Santa Short Plat, SP-19-00003, Condition Compliance Document

KITTITAS COUNTY		WASHINGTON
DWN BY	DATE	JOB NO.
S. WARD	05/2020	18-024
CHKD BY	SCALE	SHEET
SW/VW	1"=20'	2 OF 3

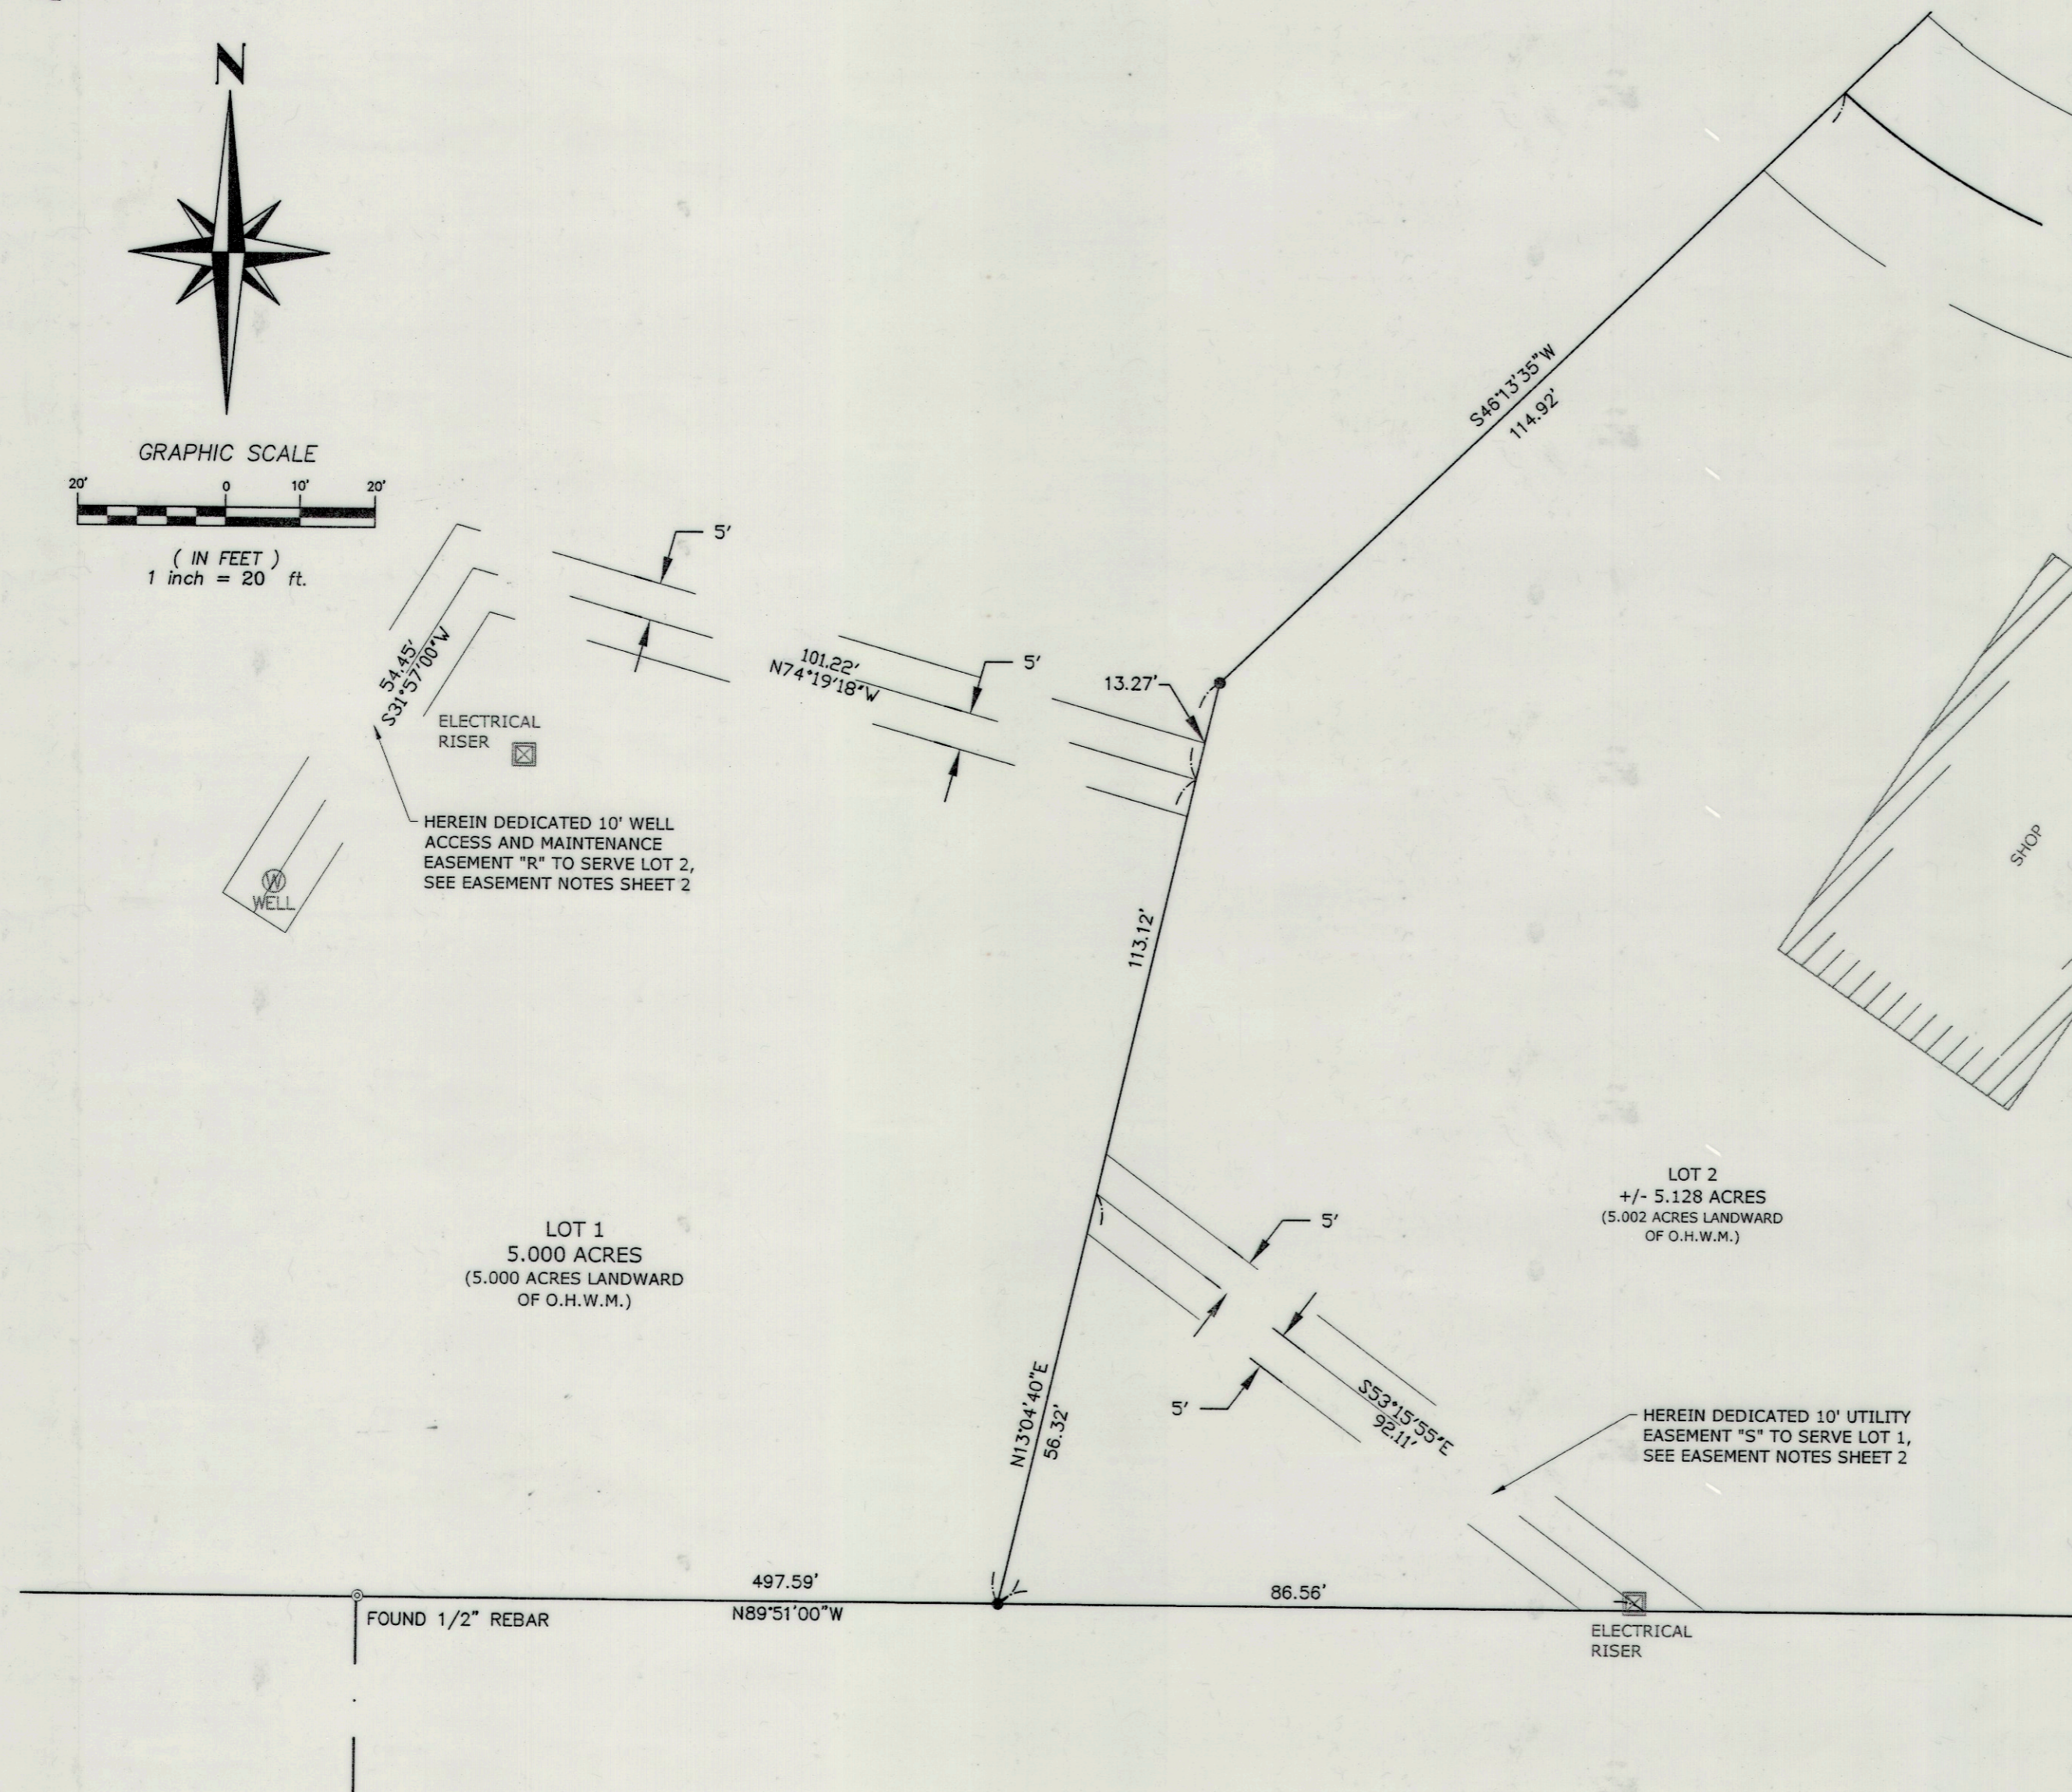
8. Survey		
A. The vicinity map cannot be color or grayscale at final recording.	Revised as requested	
B. Dimensions located at the North portion of Lot 2 are obscured by hatching.	Revised as requested

C. There will need to be an easement created for Lot 2 to access the shared Well location.	Revised as requested	
D. Per KCC: 16.12.110, Utility easements will need to be shown for the lines serving the shown electrical risers.	Revised as requested
